61 Hatfield Road, Potters Bar, EN6 1HS

Design Statement

Responses to Pre-application (23/0049/PA) comments :

PROJECT 61 Hatfield Road		FASCIA Architecture & Interior design	
DRAWING Site Plan Proposed		82 Elgin Avenue, London W9 2HB t: 07955126375 e: info@fascia-arch.com	
JOB No. 014	DRAWING No. GA 007	REV A	SIZE A3
SCALE 1:200 @ A3

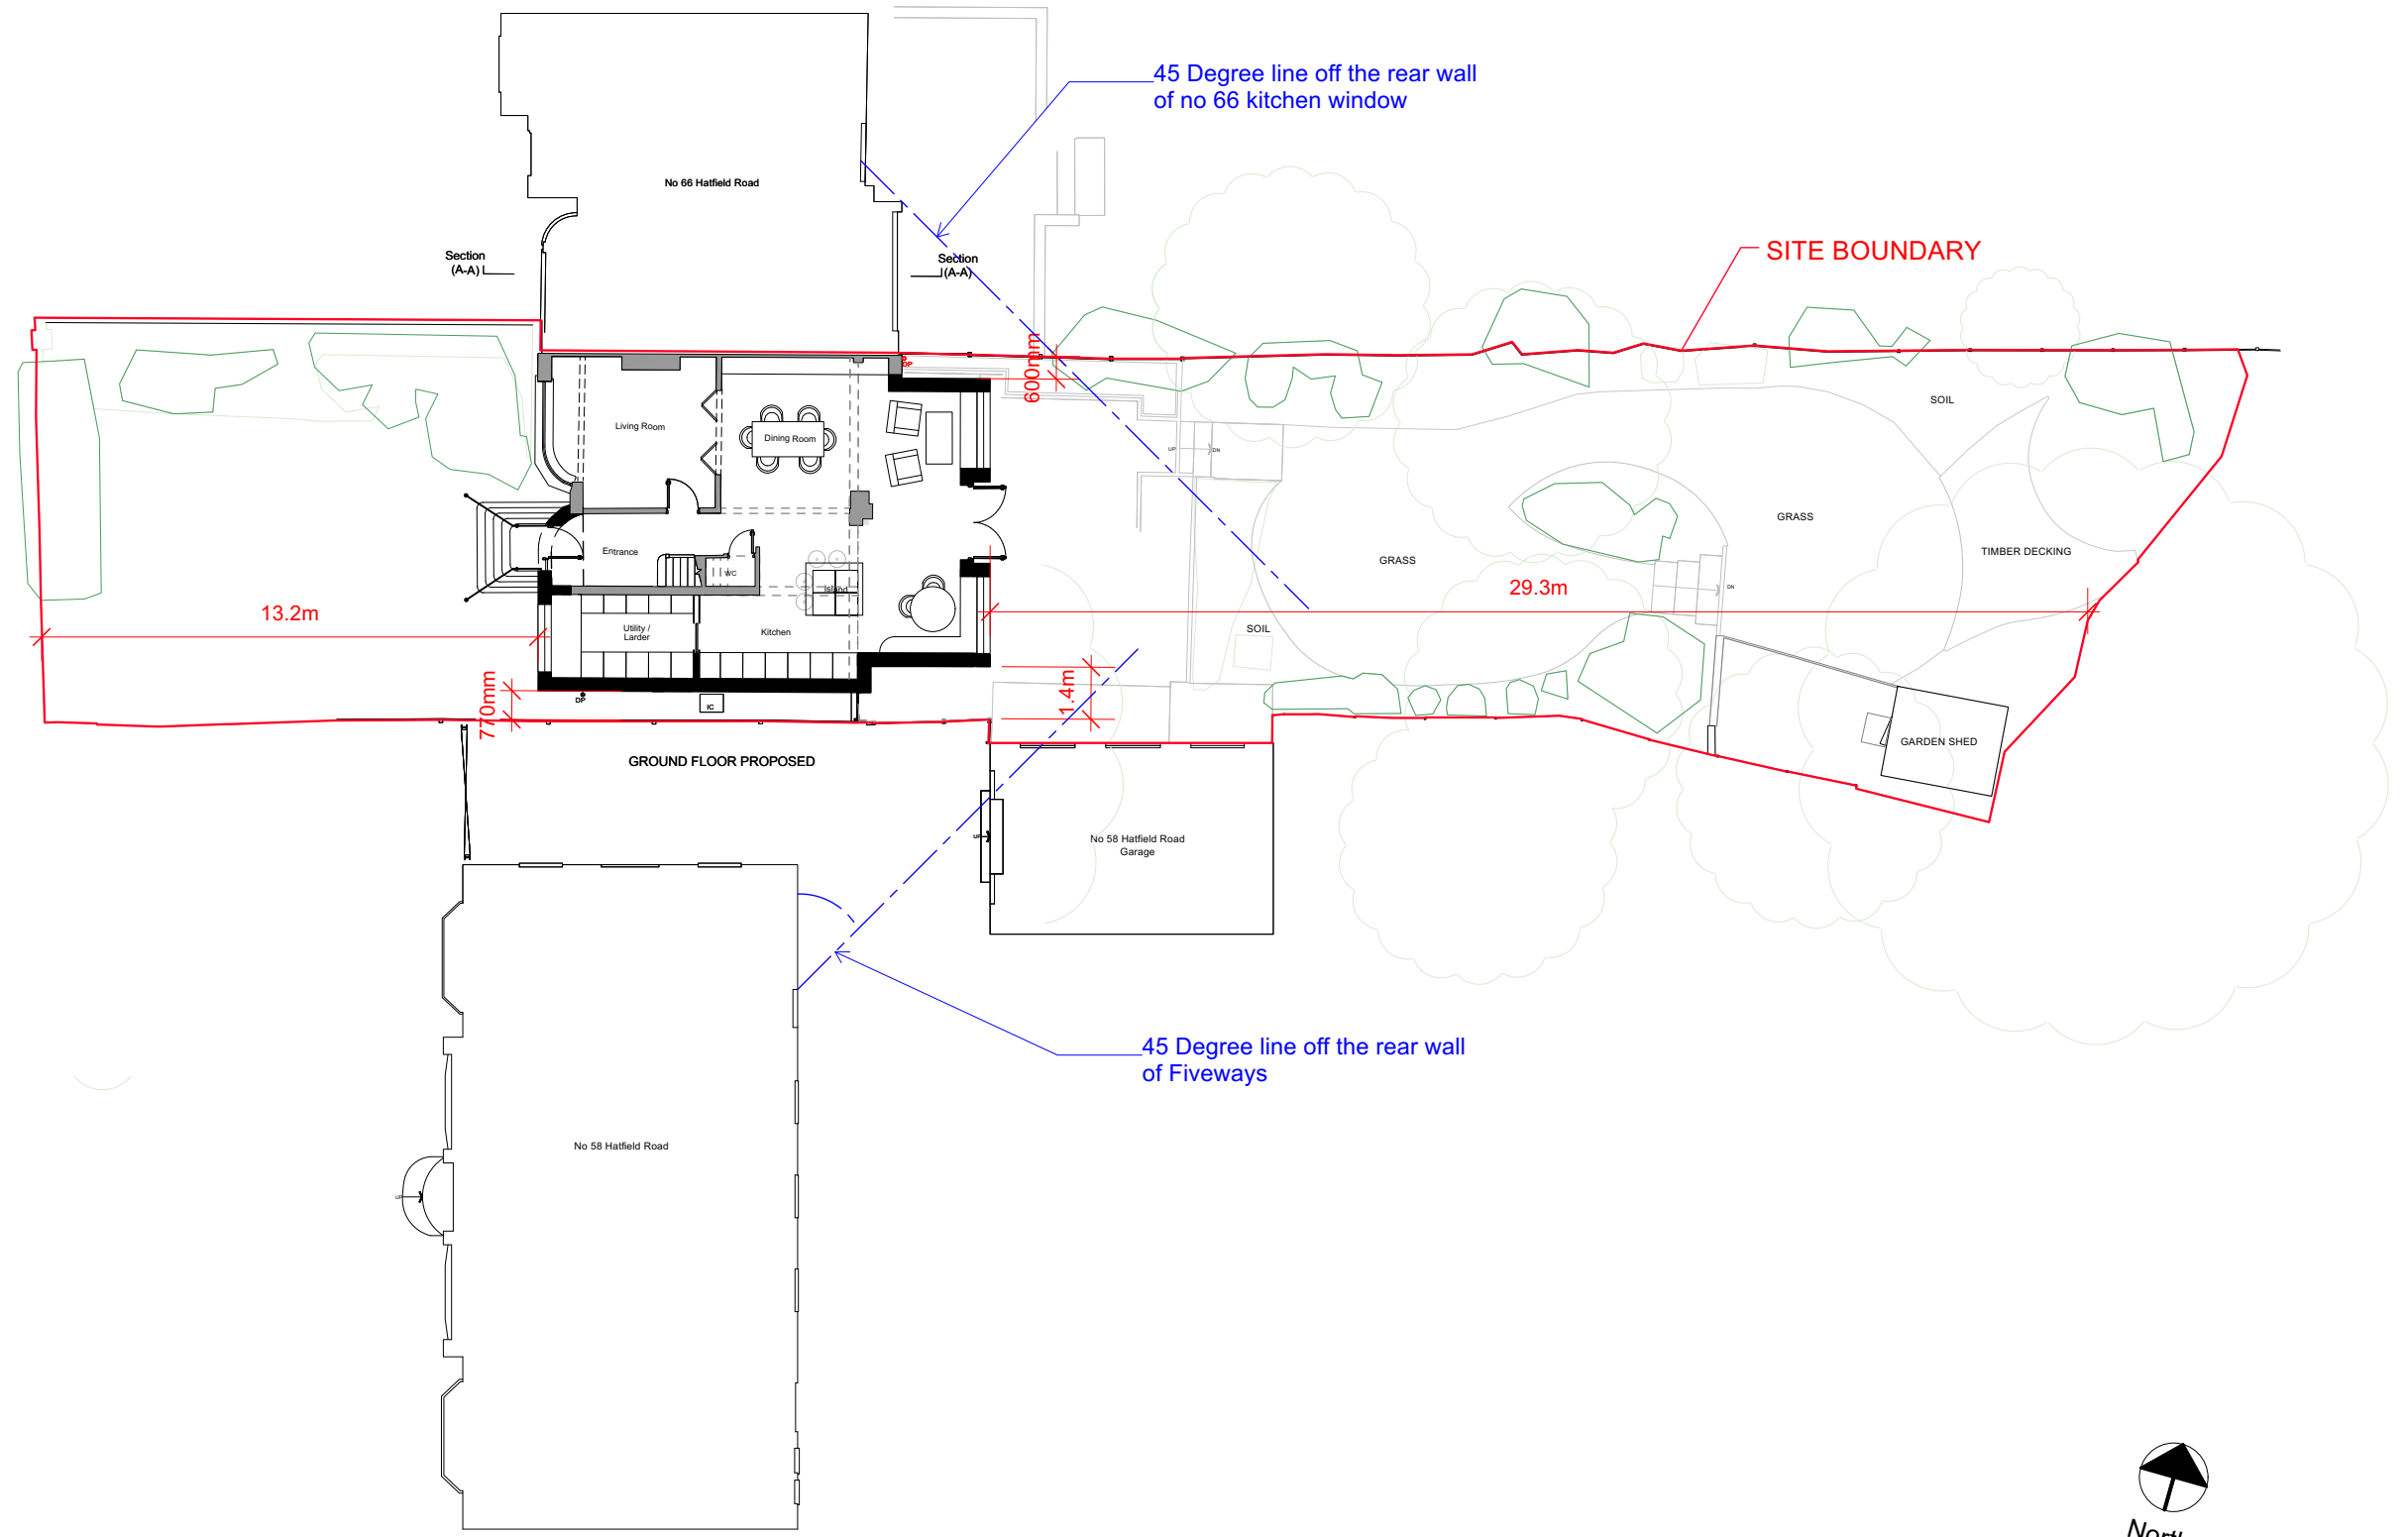
5. *"Any future scheme should include the indicative layout of the adjacent neighbours and demonstrate 45 degree compliance"*

Architect's response : See GA 007A. 45 Degree line from rear of Fiveways is not obstructed by our proposals. Our proposed rear extension breaches the 45 degree line when taken from the corner of the existing living room extension window at no 66 Hatfield Road.

However, given that this window extends almost to the boundary line of no 61 Hatfield, it would be impossible not to breach this 45 degree line with any extent of rear extension. The 45 degree line from the existing kitchen window at no 66 Hatfield is maintained as part of these proposals. Drawing your attention to the below excerpt of your planning guidance to this effect :
